Site: 4719 86th Ave SE SP
Mercer Island, WA 98040
TPN: 7598100420
Area: 28,644 sq ft. = .66 acres

Re: RFI dated February 2023 all corrections highlighted in yellow

City Arborist

### TREE RETENTION CALCULATION

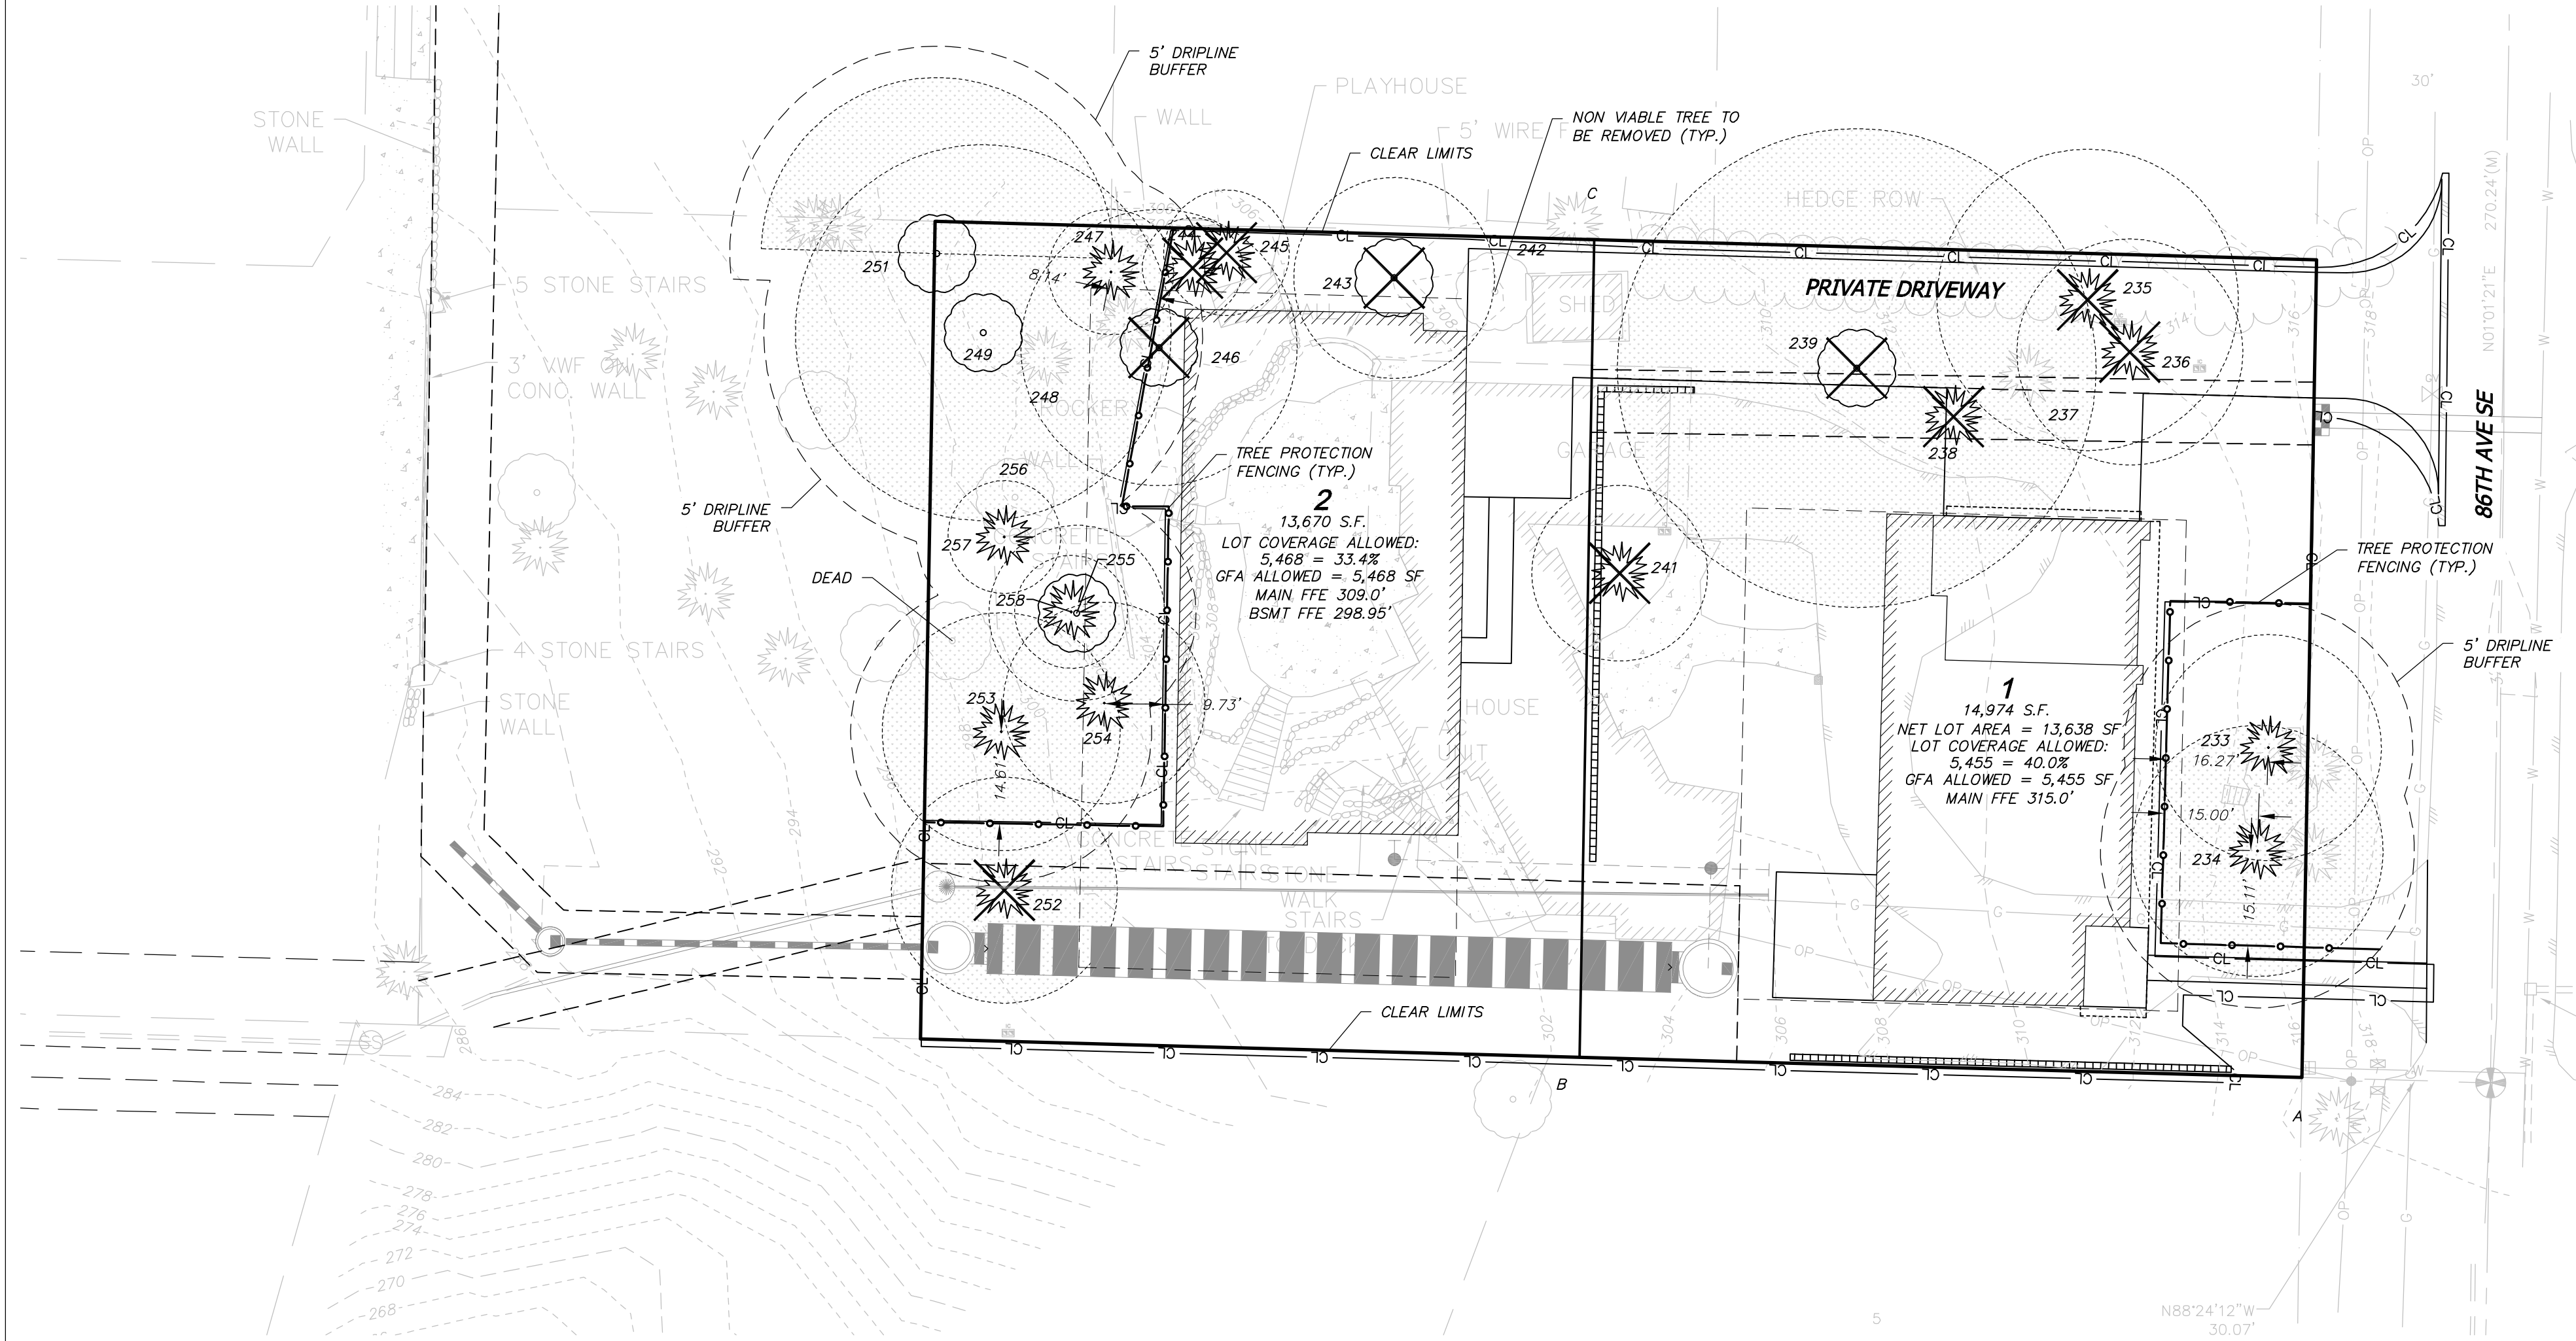
8. Please move the building pad and over excavation outside of the critical root zones of trees 233, 234, 249, and 253. Air excavation root analysis will need to be provided prior to construction to demonstrate that these trees will not be damaged by the proposed work. The analysis will need to call out the specifics of the project design. Alternatively, these trees could be proposed to be removed if the minimum required number of regulated trees will be retained. The building envelope was moved 5' to the west to reduce the potential impact of construction on tree #233 & 234) I have reduced the LOD by a 2' and 5' respectively (see "Onsite Tree Observation Table on pages 7-11). The soil around the roots will be air-evacuated and the exposed roots will be cut cleanly to BMP, ANSI 300 and ISA standards.

9. Please provide a tree replacement plan for at least 49 trees. If you can show that there is not enough space on the lot for the required replacement trees, you may request a fee in lieu that charges \$919 for each tree that cannot be replaced. A bond or assignment of funds will be required at the final plat, which will be completed before building permits for the lots are finalized.

1. Retain tree number 255
2. Retain tree number 254, LOD moved to the iCRZ
3. Retain tree 258
4. Remove the retaining wall south of trees 253 and 254 to protect additional root zone, as well as moving the LOD east of tree 254 to 2' from the east side of the foundation. The foundation in this area must be hand dug after air-evacuating the roots.

A single large tree grove is formed between trees # 244 - 249; and trees 251- 257. Mitigation for the proposed removal of four (4) of these trees requires a 6:1 replacement. This proposal retains several additional trees, so the overall required mitigation is reduced to thirty-four (34) trees; however, the site will only accommodate fifteen (15) replacement trees requiring a fee-in-lieu-of (34-15) = 19 trees or 19 X \$919 = \$17,461.
